Office of Environment & Heritage

Your reference: MP07_0118 MOD 1
Our reference: DOC 14/44274
Contact: Virginia Thomas 6229 7105

RE: Gullen Range Wind Farm – MOD 1.

Thank you for your letter, received by email on 3 April 2014, requesting a submission from the Office of Environment and Heritage (OEH) on Modification 1 to the Gullen Range Wind Farm. OEH provides the following comments on the Modification report (MOD 1), in relation to biodiversity and Aboriginal heritage.

# APPENDIX 1 PROJECT LAYOUT

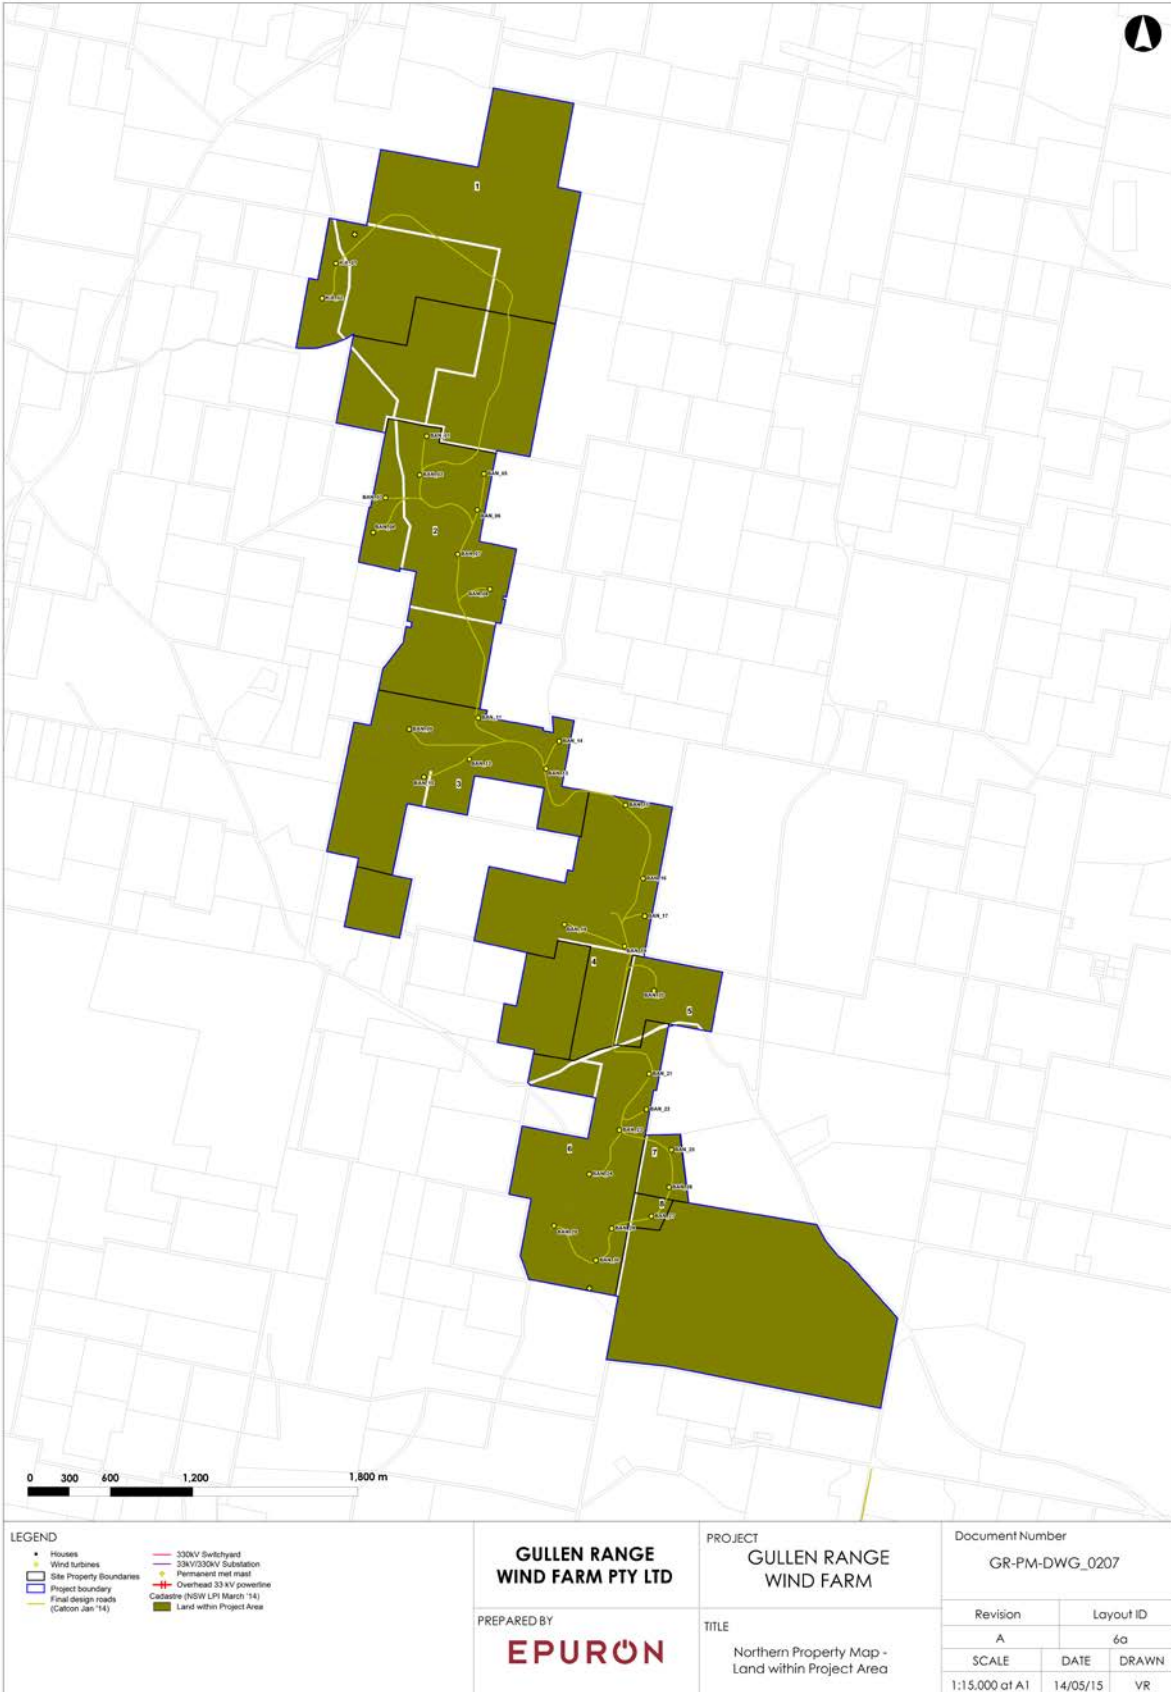
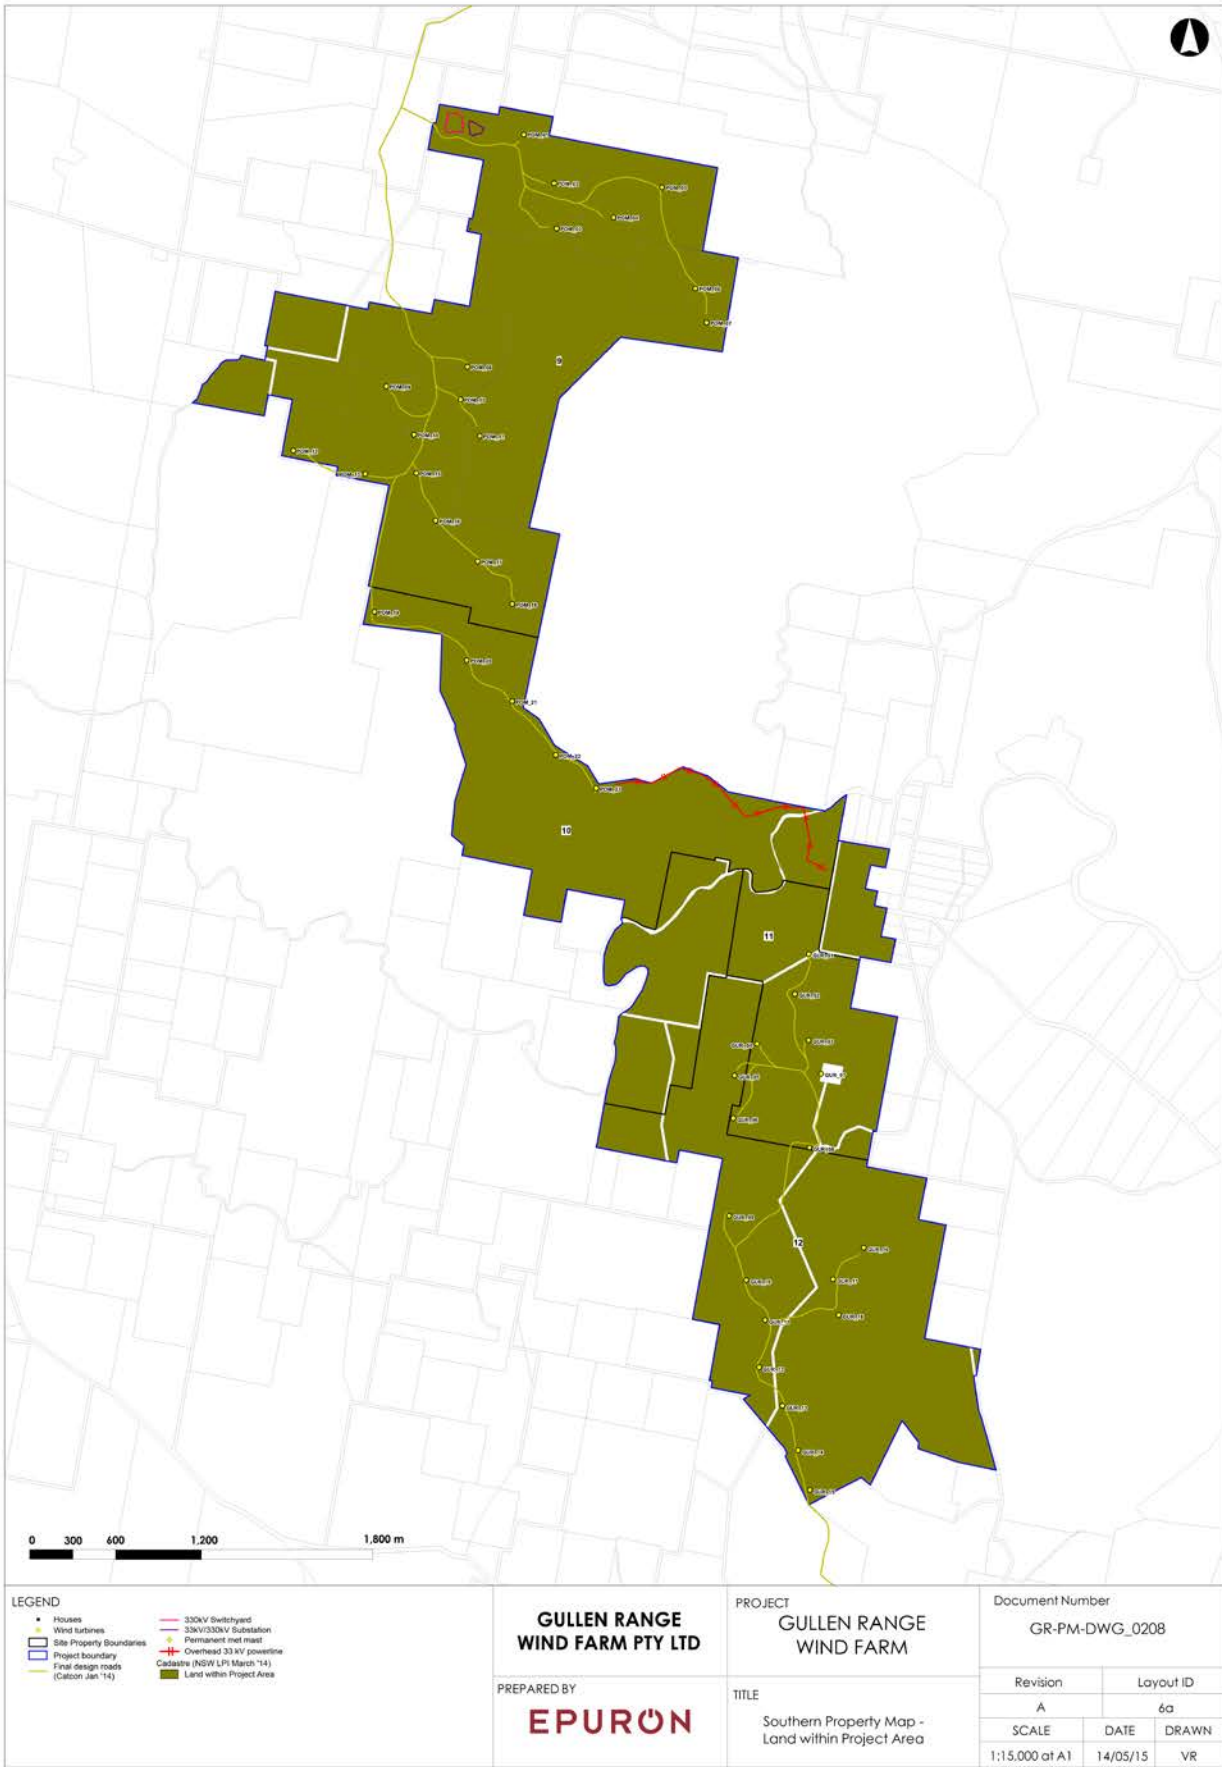
OEH notes that the modification seeks endorsement for the relocation of 69 of the 73 approved wind turbines between 1 and 187m from their approved locations. OEH considers that there is little scope for objection considering all turbine footings have been constructed and 58 turbines have already been erected.

There is no mention in the CHP report of turbines or infrastructure being constructed within the offset area. The Map included in the CHP indicates the turbines are right on the edge of the compensatory habitat area, however no roads or other infrastructure are shown within the area. The MOD 1 report indicates that two turbines (POM_06 and POM_07) and associated infrastructure have been constructed within the offset area. POM_06 has been moved into a patch of “degraded Box Gum Woodland EEC”. The MOD 1 report states: “*the constraints mapping is designed to protect the viability of the overstorey vegetation which in this location is sparse*”, and yet a tree was removed in this area of EEC to reposition the turbine 57m from the approved location. The report also states “*due to an error in GIS mapping, the location of POM_06 was not identified by the Principal Contractor, as being within an area of EEC. At the time of construction the ecologist did not identify the area as an EEC due to the extent of the degradation by infestation with Serrated Tussock.*” OEH seeks clarification of how this happened within the offset area, given the offset had been mapped as 70% EEC. OEH has identified that

the offset area indicated in the CHP appears to have a significantly different boundary than the area indicated in the MOD 1 as the offset area. OEH therefore requests clarification why the boundaries were altered and turbines placed in the Offset area.
